**Consultation Response from KC,  
Highways Development Management**

**2025/91168 Wilton Mills, 586, Bradford Road, Batley, WF17 8LP**

**Demolition of existing garage and erection of MOT bay/service area (within a Conservation Area)**

**Date Responded: 23-7-2025.**

PROPOSED BLOCK PLAN (SHOWING INDICATIVE DRAINAGE PLAN), 1:1200

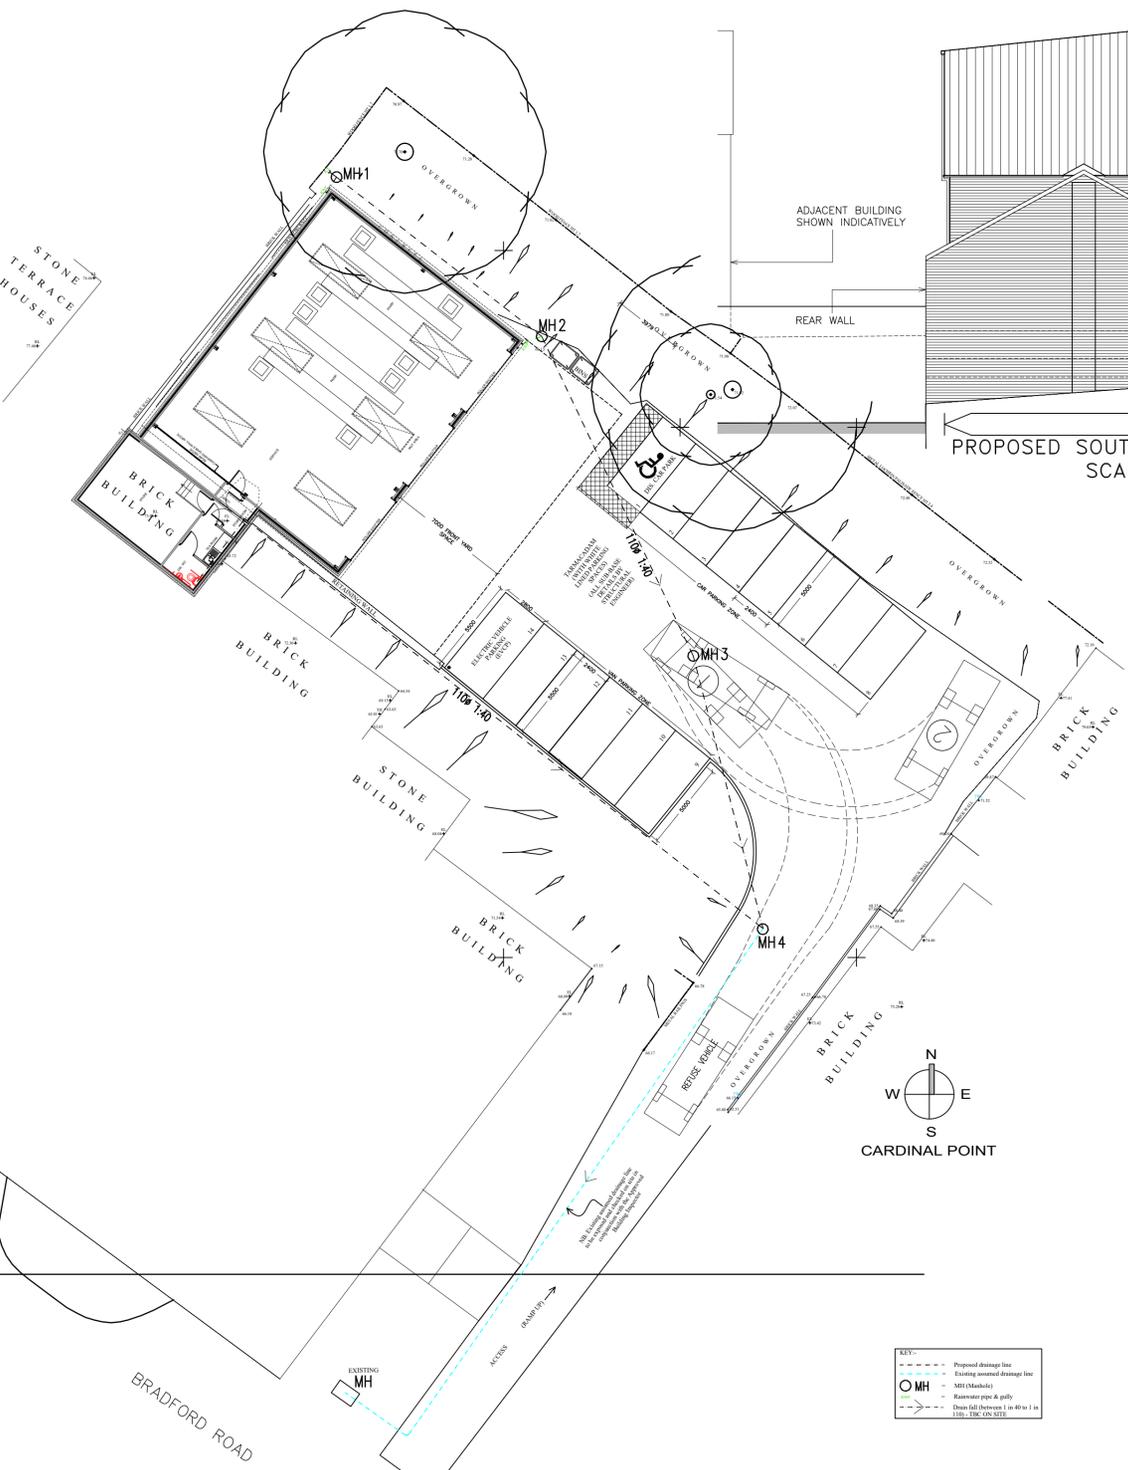
This application is like the two previous approvals. These proposals show a 7-metre-deep forecourt to the frontage of the proposed building, a further 14 off-street parking spaces including disabled and electric vehicle parking spaces, a bin storage point and space for internal refuse vehicle turning.

Whilst the proposals show refuse vehicle turning the swept paths provided are not for a 11.85m refuse vehicle and the access may be too steep to allow refuse vehicle access. Condition 9 attached to the 2018 permission should therefore be repeated for this application.

**Details of storage and access for collection of wastes**

Before development commences details of storage and access for collection of wastes from the premises shall be submitted to and approved in writing by the Local Planning Authority. The approved details shall be provided before first occupation and shall be so retained thereafter.
